Appeal Decision

Appeal Ref: APP/R4408/W/19/3240735

119 Cross Lane, Royston, Barnsley S71 4AR

Project.	119 CROSS LANE ROYSTON BARNSELY	Client.	
Drawing Title.	HOUSE TYPE	Date.	JUNE 2019
		Scale.	1:100 @ A1
		Ref.	05-117
		Dwg. No.	03
		Rev.

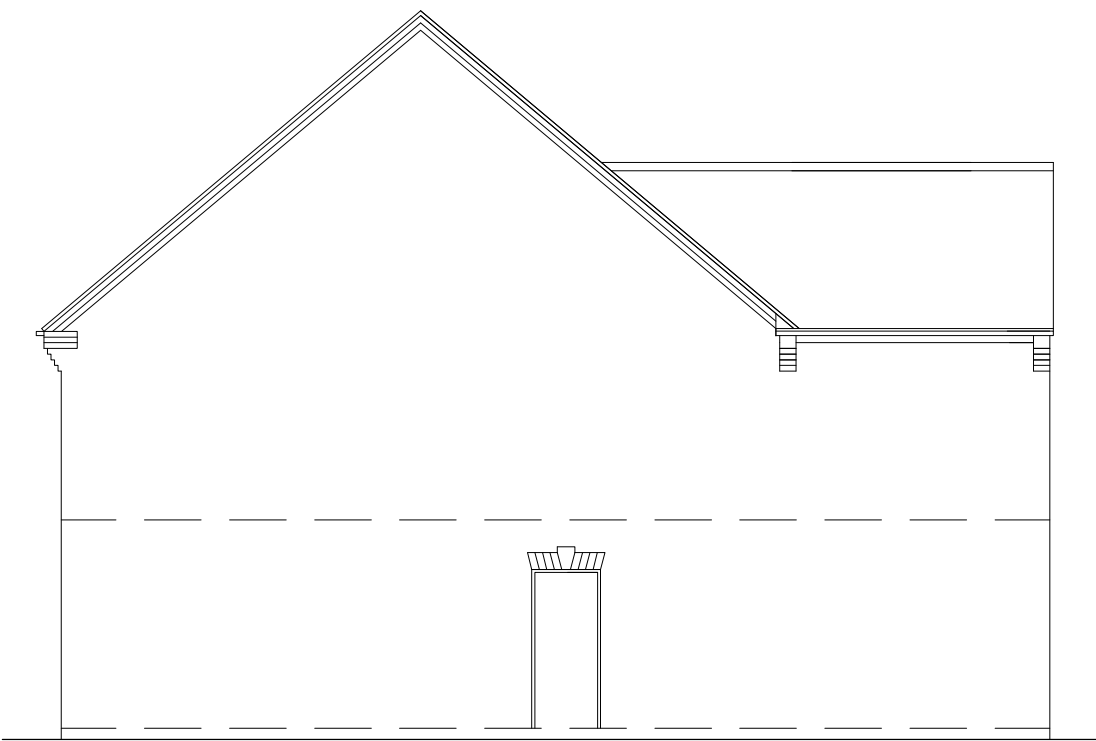
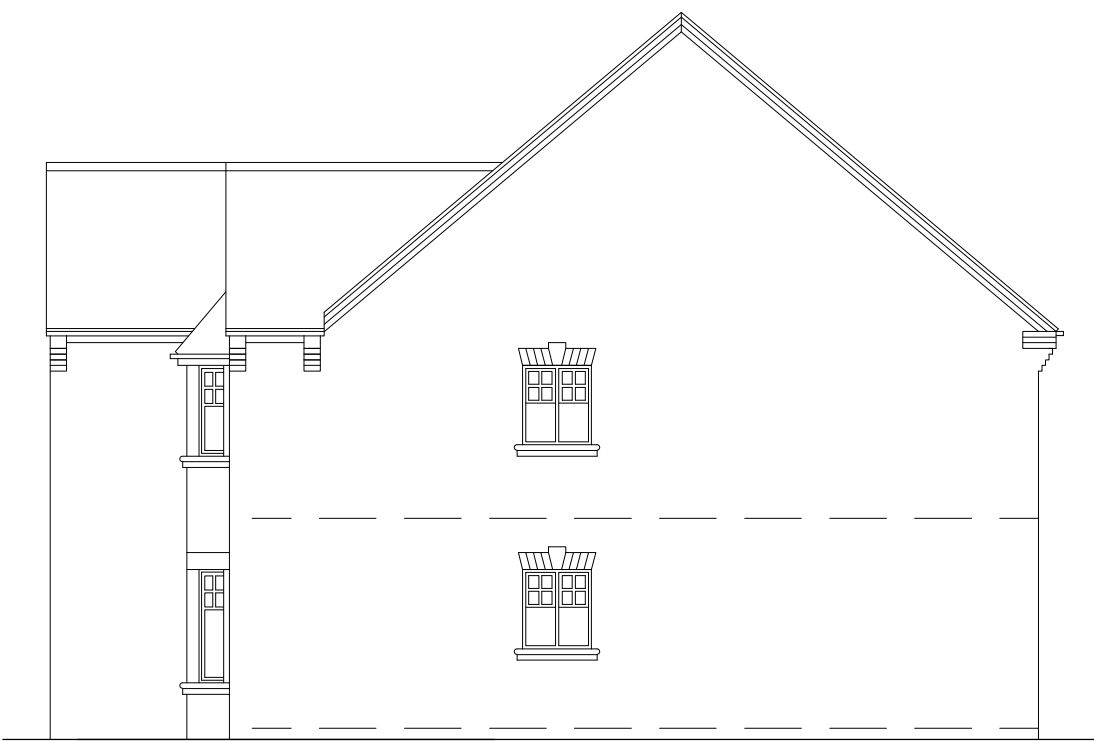
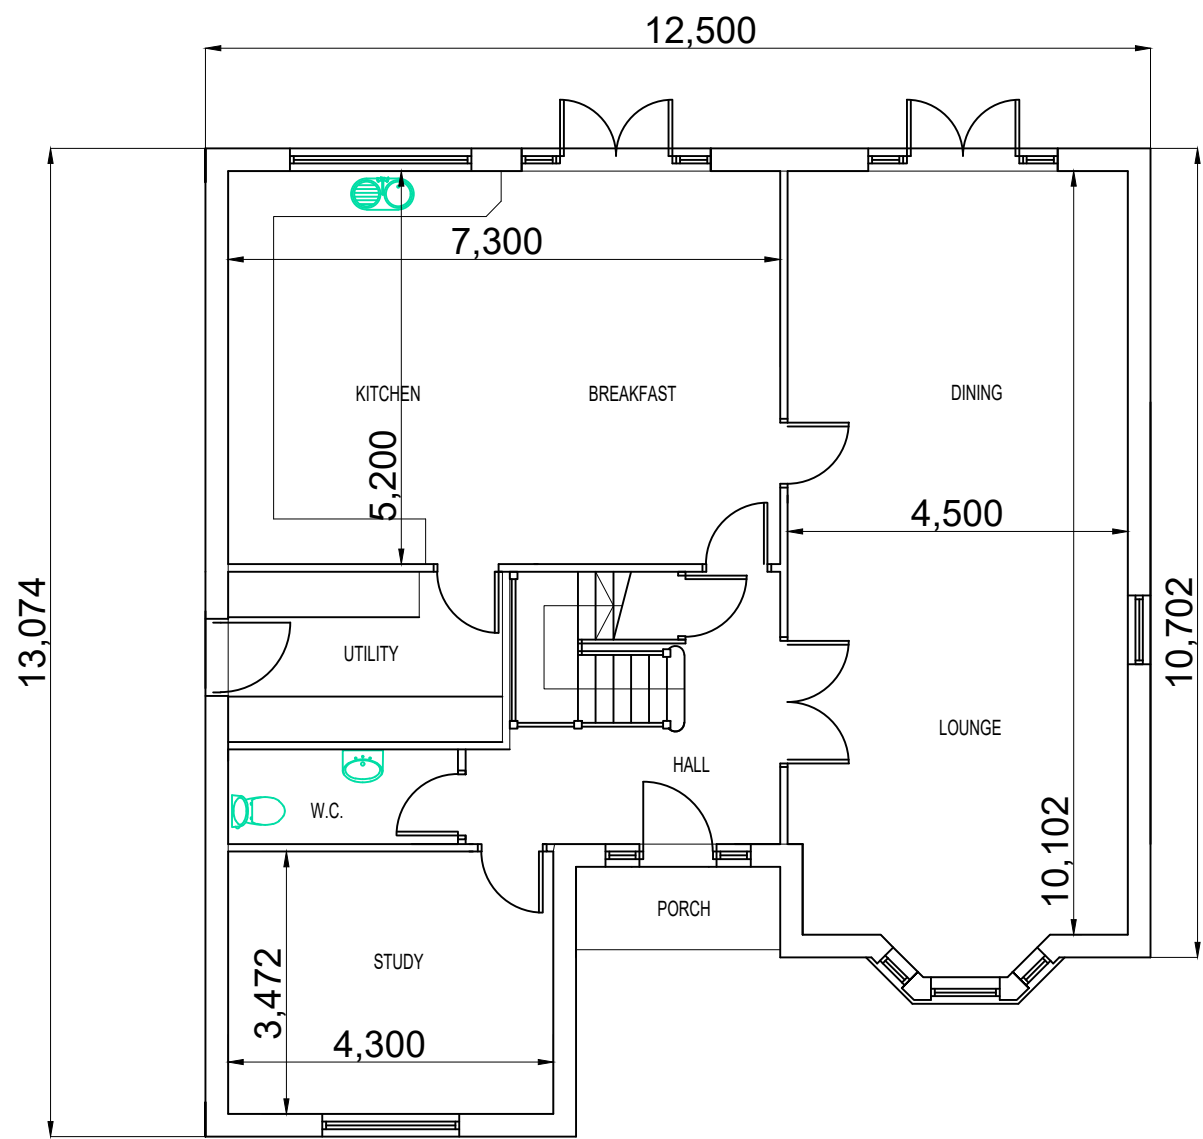
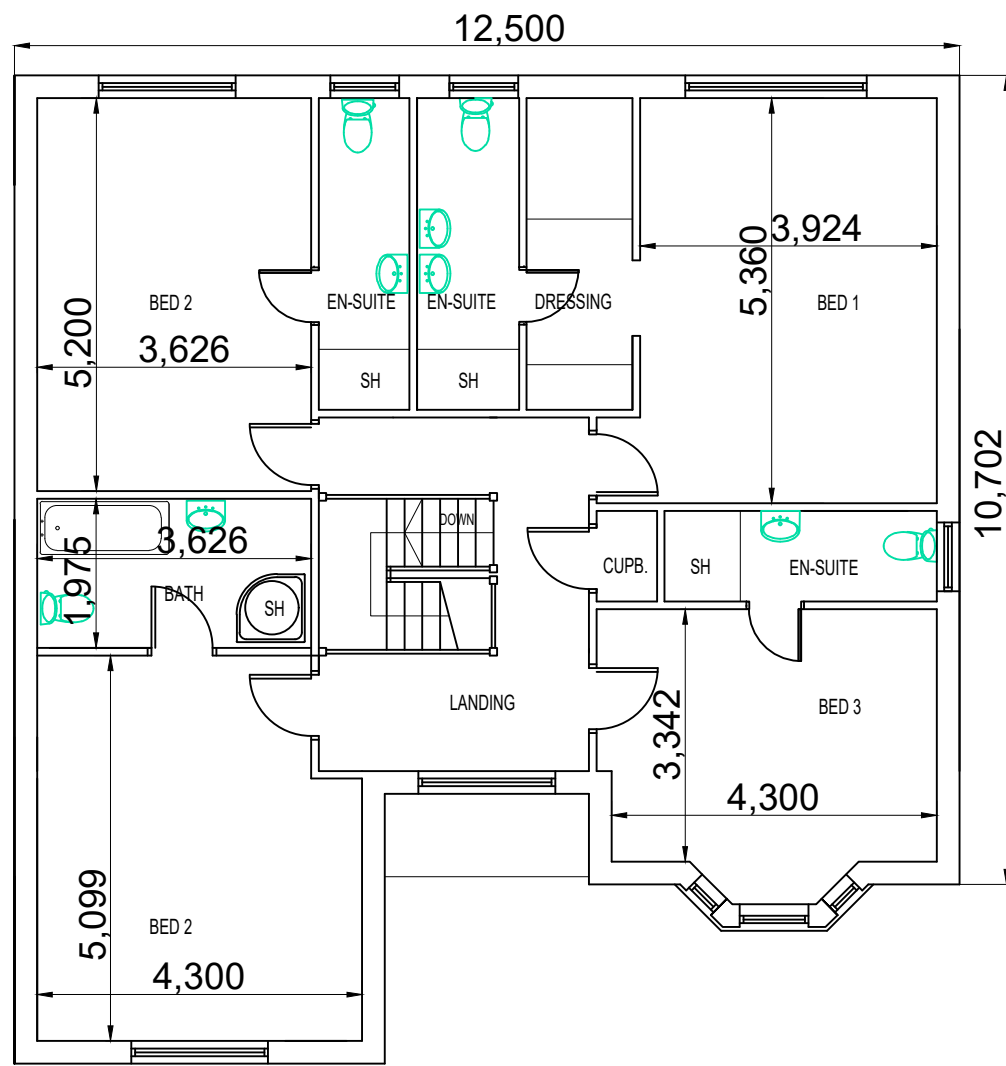
6. The proposed dwelling would be a large, double fronted detached dwelling on a plot that is substantially wider and longer than those that surround it. As such, the proposal would be at odds with the prevailing character and appearance of the location which is of modest, tightly knit properties on narrow plots, usually with direct road frontage.

9. In the context of the above, I find that the proposal would in terms of its design, scale and position introduce a development that would be out of keeping with the urban grain of the locality and thereby harmful to the character and appearance of the area. Consequently, it would conflict with the design and placemaking requirements of LP Policy D1 and the SPD.

11. Based on the information I have been provided, it is clear that the proposed dwelling would exceed the separation distances set out in the SPD. However, I note the presence of a raised terrace and Juliette balcony located close to the southern boundary of the appeal site. These features would allow views into the outdoor amenity space of the proposed dwelling and conversely, occupiers of the proposed dwelling would be able to see users on the raised terrace.

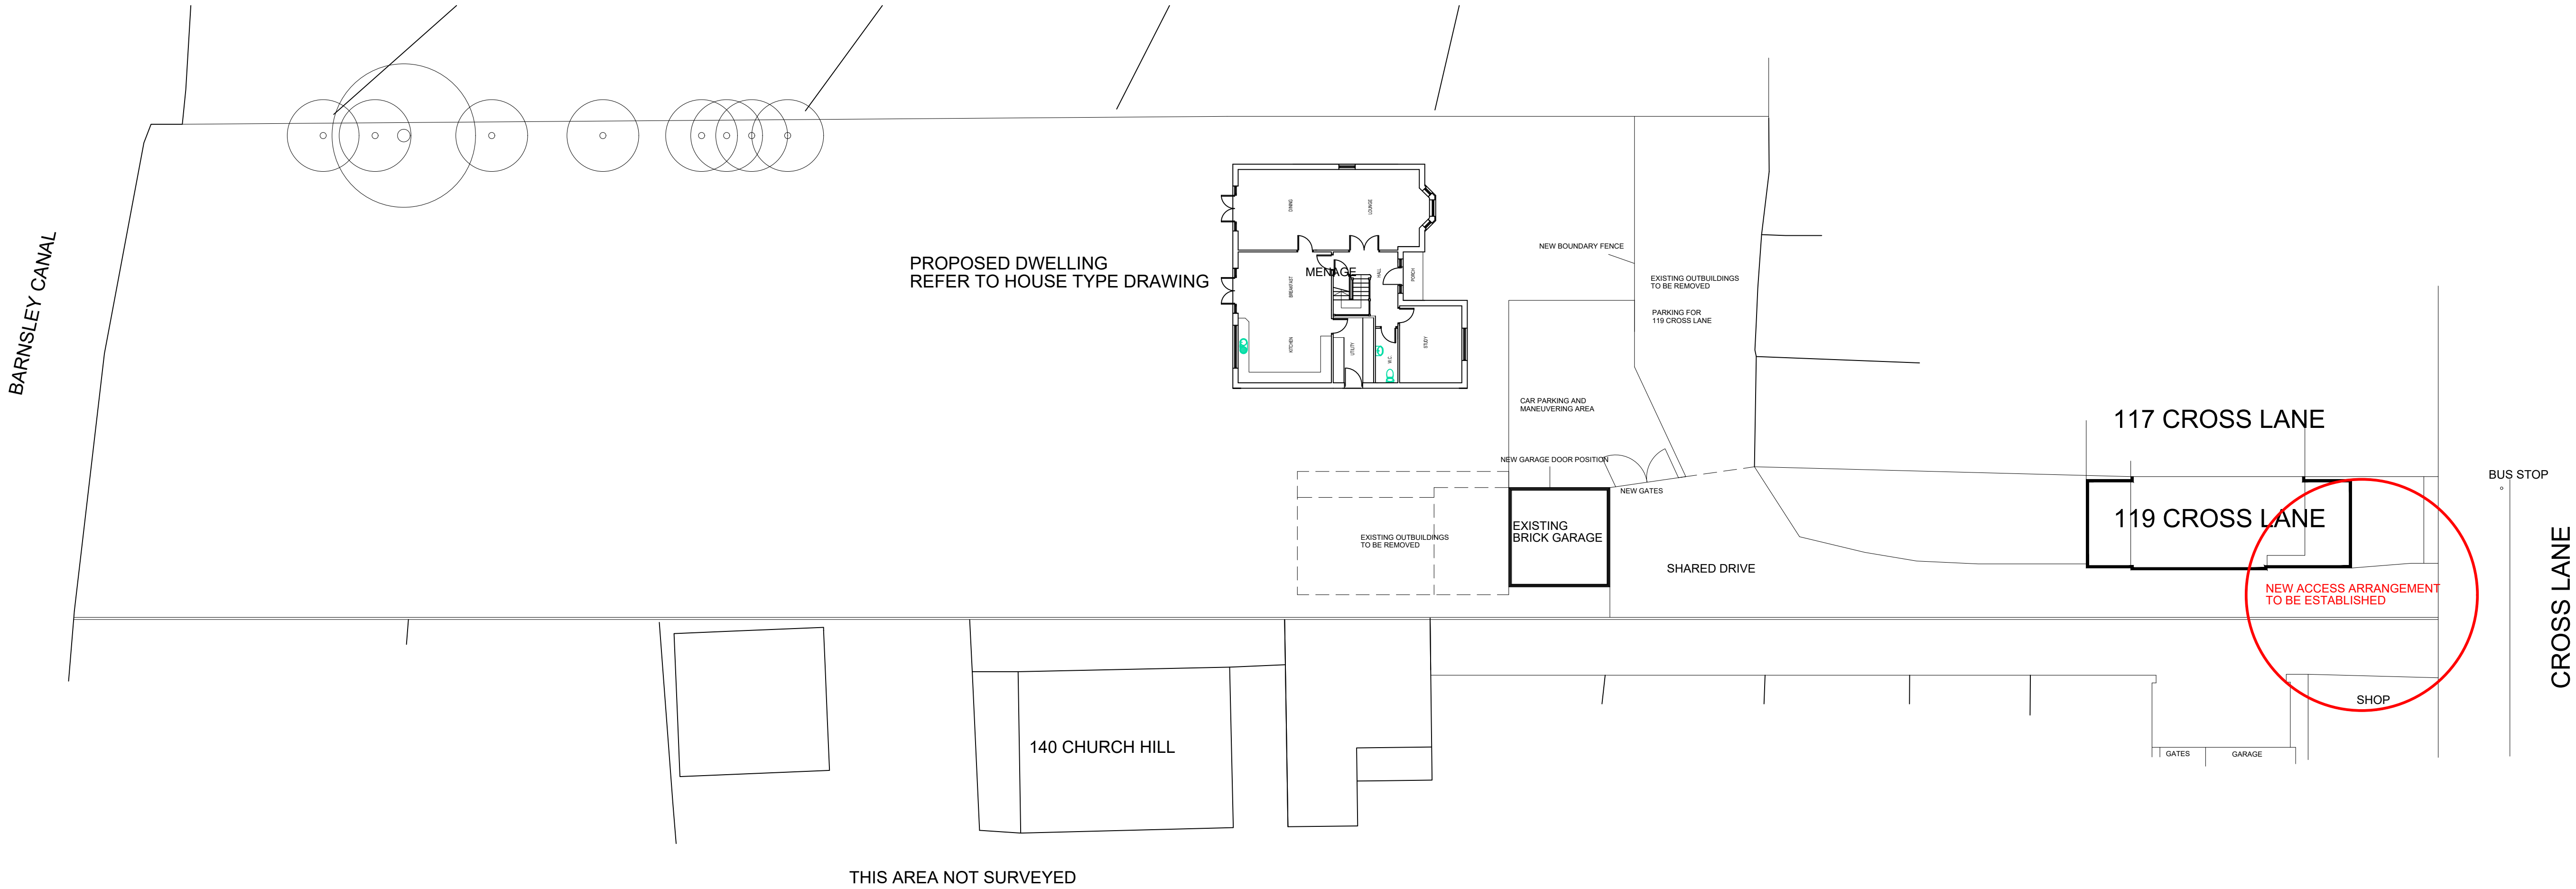
5. The proposal includes the development of one detached residential dwelling to the rear of the host property. Access would be via the existing single width driveway. The existing detached garage would be re-purposed to serve the proposed development. The house would sit towards the north eastern corner of the appeal site facing west towards Barnsley Canal.

8. LP Policy D1 requires development to be of high quality design that complements, respects and reinforces local character. Furthermore, guidance contained within Supplementary Planning Document - Design of Housing Development 2019 (SPD) seeks to resist tandem development where one house is directly in front or behind another and development that is accessed via long, narrow private driveways.

12. Nonetheless, given the size of the proposed outdoor amenity space for the proposed dwelling I do not consider that some overlooking into a small part of the garden would have a significantly detrimental impact on the privacy of its occupiers. Similarly, I consider that an appropriate boundary treatment to the southern boundary would suitably protect occupiers of properties adjoining the southern boundary from overlooking.
